Our Ref: PAA/171/16/

Pre-Application Advice

Removal of the existing double door and window of the existing single-storey rear extension to accommodate a bi-folding door unit with a pass door and the erection of an upper floor extension above the existing single-storey extension similar to the adjoining No. 14 Scott Street.

15 Scott Street Bognor Regis West Sussex

02 Proposed First Floor Plan

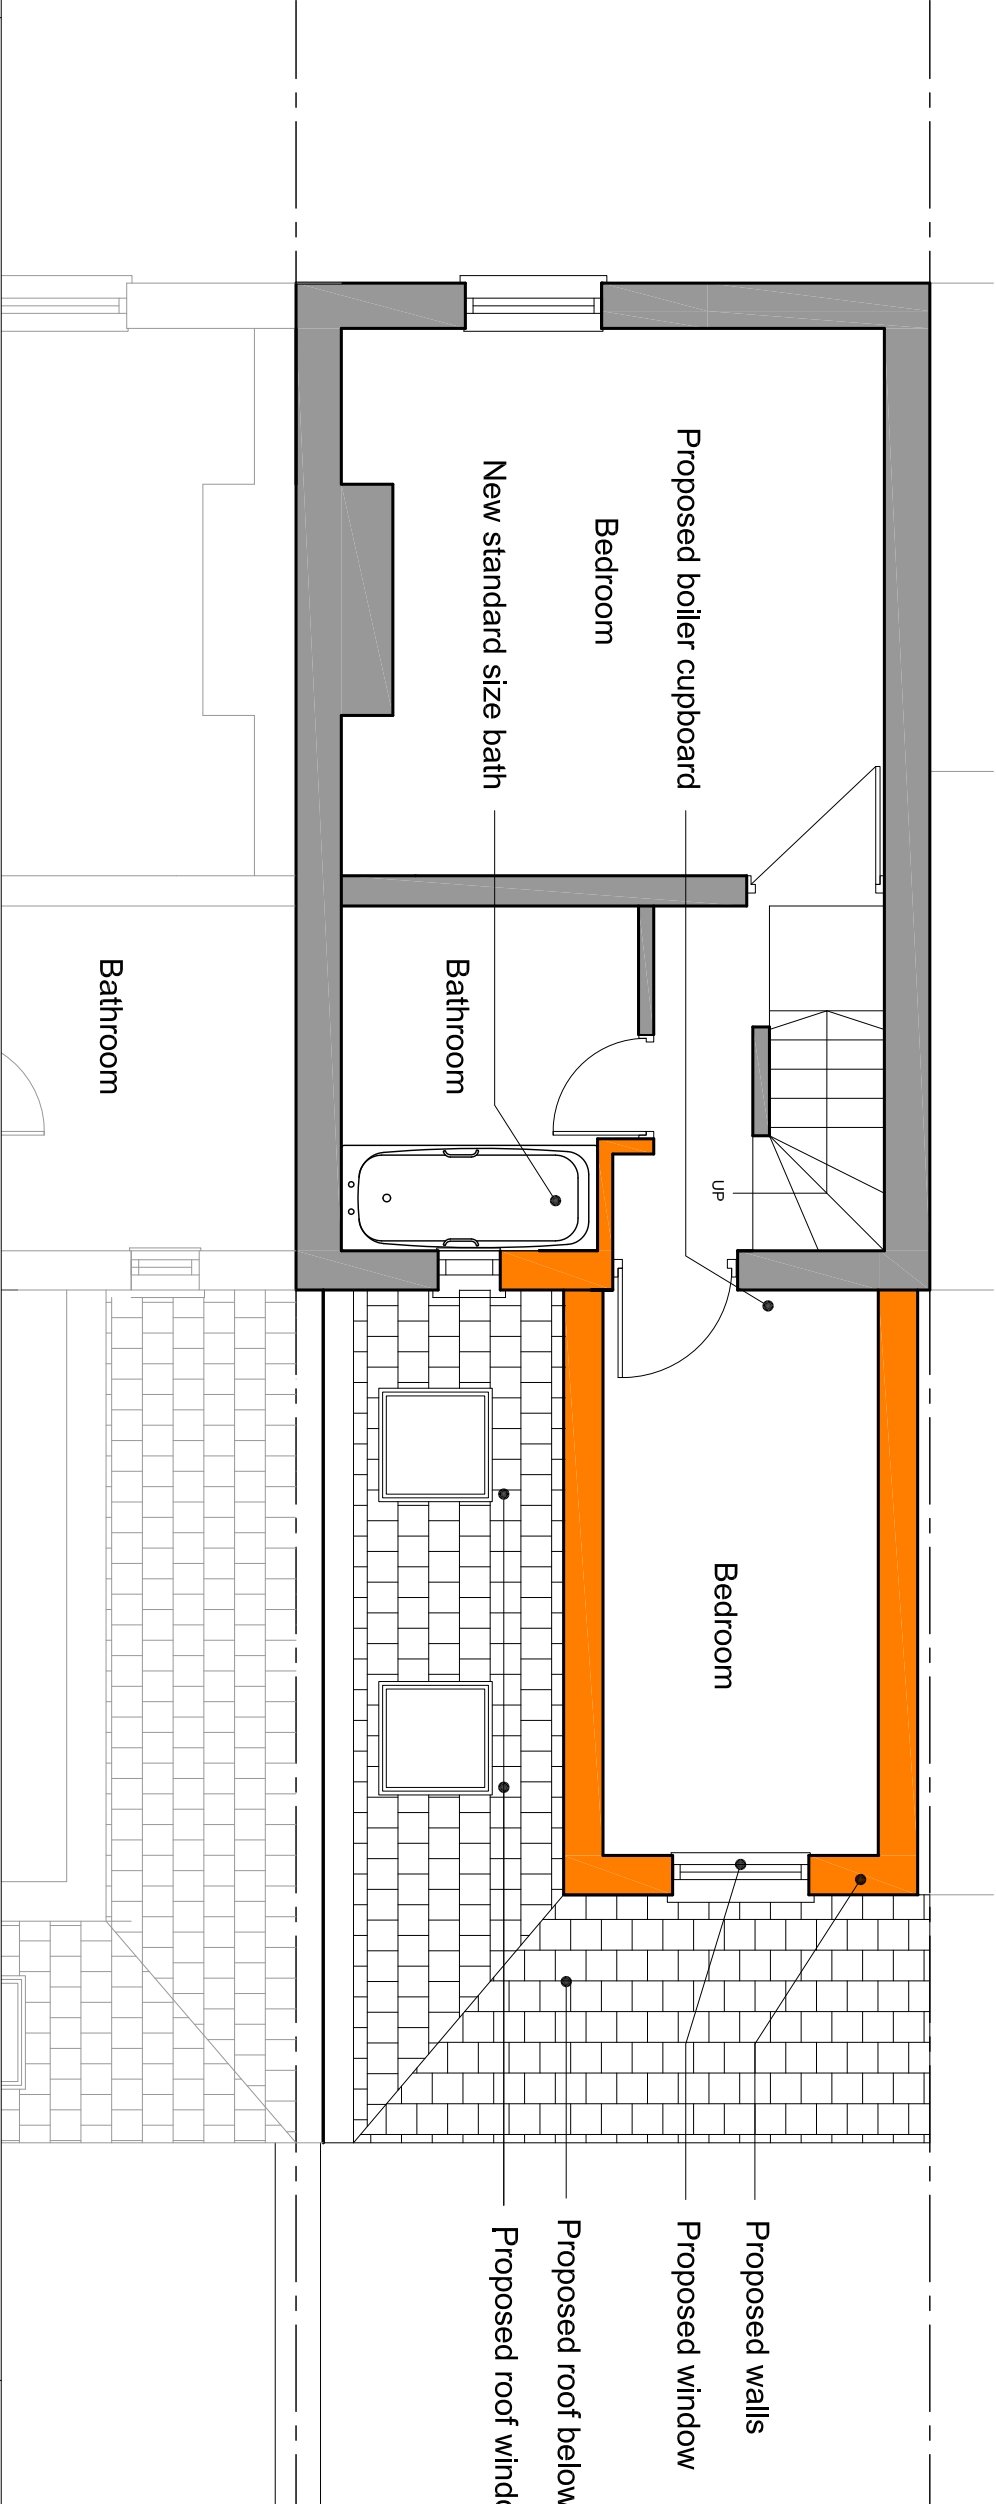
The proposed development is considered to be potentially acceptable as the main neighbouring property to be effected would be number 16. This has an existing ground floor rear return. However, a point of contention is that the proposed first floor extension fails the 45 degree test to the middle of the nearest window of 16. This should be considered prior to an application being made.

02 Proposed Roof Plan

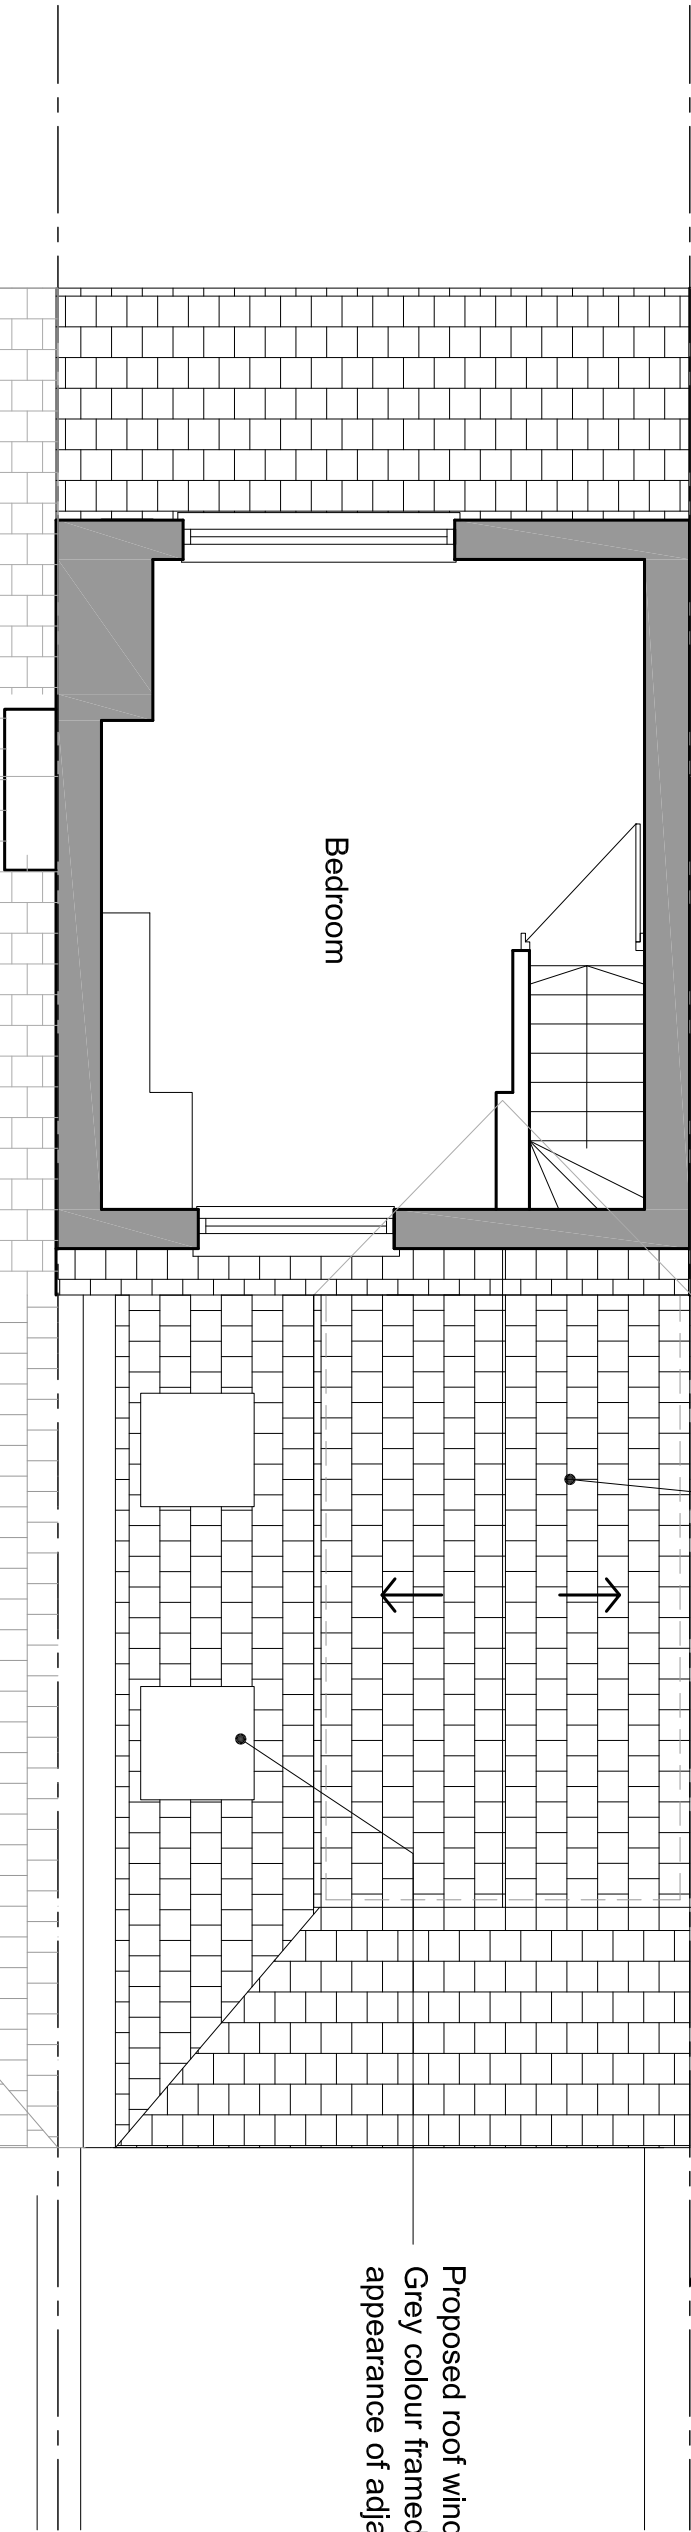
A further concern is the roof which wraps around the addition. On the drawing of the south elevation the roof is shown as a partial crown roof (with flat roof) which would not be supported. On the roof plan however the roof here is fully sloped. This requires some clarification.
